Item No. **Report of the Head of Planning, Building Control, Sport & Green Spaces**

Address LAND ADJACENT TO 171 NORTH HYDE ROAD HAYES

Development: Erection of two storey building comprising ground floor shop, two bedroom flat at first floor level and associated parking (Part Retrospective)

LBH Ref Nos: **11980/APP/2015/1160**

Roof Plan

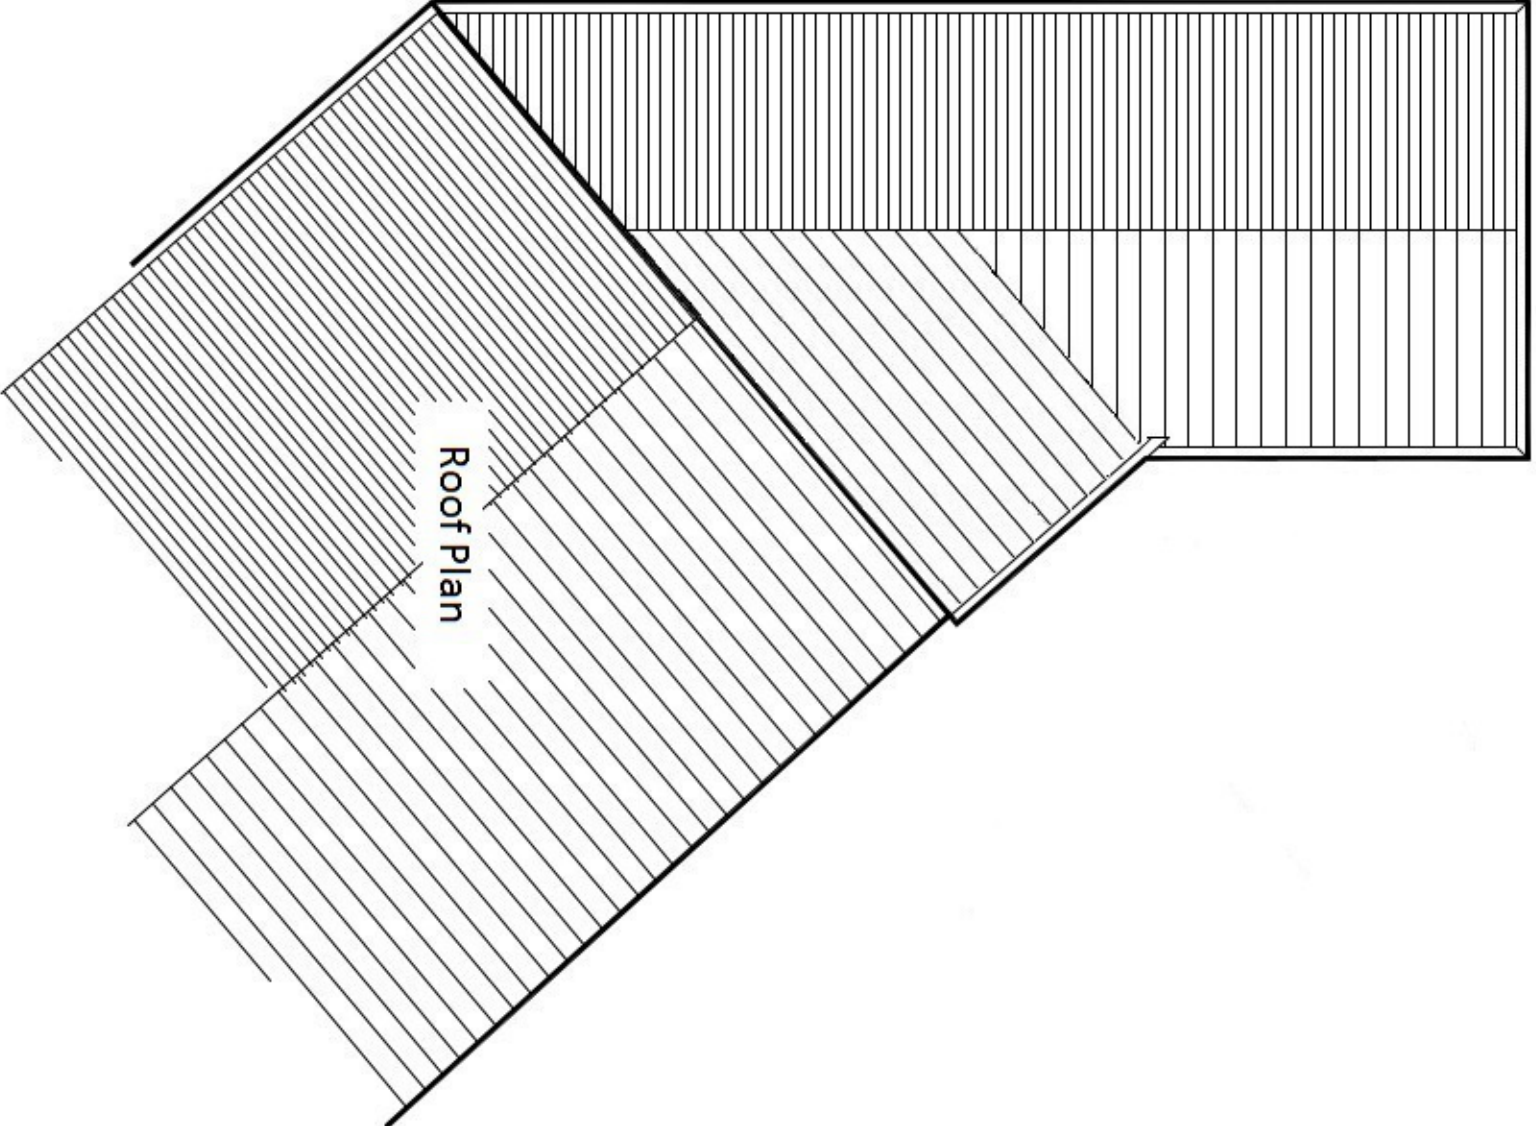
The proposal is to authorise the existing development comprising the erection of a two-storey building with end gable roof with shop/office on ground floor, two bedroom flat on the first floor and an open carport to the rear as shown on drawing no: 11/UB34NS/001 Rev. B received 22nd May 2015. The rear dormer, first floor side gable window and walls and gates surrounding the car port are to be removed as part of this re-submitted scheme. The internal layout of both the shop/office and the upstairs flat have also been revised and are acceptable.

The previous application provided 2 open ended car port spaces for 2 covered spaces for the first floor flat. On the sides of the car port was shown an open area with railings which provided visibility as well as security. this arrangement was approved. However, the applicant inserted windows into the areas where railings had been agreed and extended the carport with a 2m high wall on both sides to the service road installing timber gates effectively closing in the carport area. The applicant has stated that this is for security purposes as builders materials and equipment were constantly being stolen and also for the increased security of the future tenants.

However, the walls and the gates are considered to reduce visibility significantly when existing the carport and the Highways officer recommended a refusal based on highways grounds. In previous correspondence stating:

Pedestrian visibility splays of 2.0m x 2.0m are required to each side of the open and covered parking bays where the timber gates meet the rear access road. There should be no obstruction within the visibility splays over a height of 0.6m. The open gates and the supporting walls to the covered car parking bays would present unacceptable obstruction to pedestrian visibility splays.

It was then proposed to reduce the height of the walls to 0.6m with railings above but with the timber gates opening inwards these would still block visibility and further amendments were sought to remove the wall and the rear gates in their entirety. This is shown on the plans received 22nd May 2015 of which the Highways Comments of the 26th May 2015 relate.

The removal of the rear dormer

The removal of the rear first floor gable end window

The removal of the eastern wall and the rear timber gates of the car port

The removal of the door leading from the ground floor A2/B1 office to the car port.

The blocking up of the entrance door between the internal staircase to the first floor flat and the ground floor A2/B1 office unit.
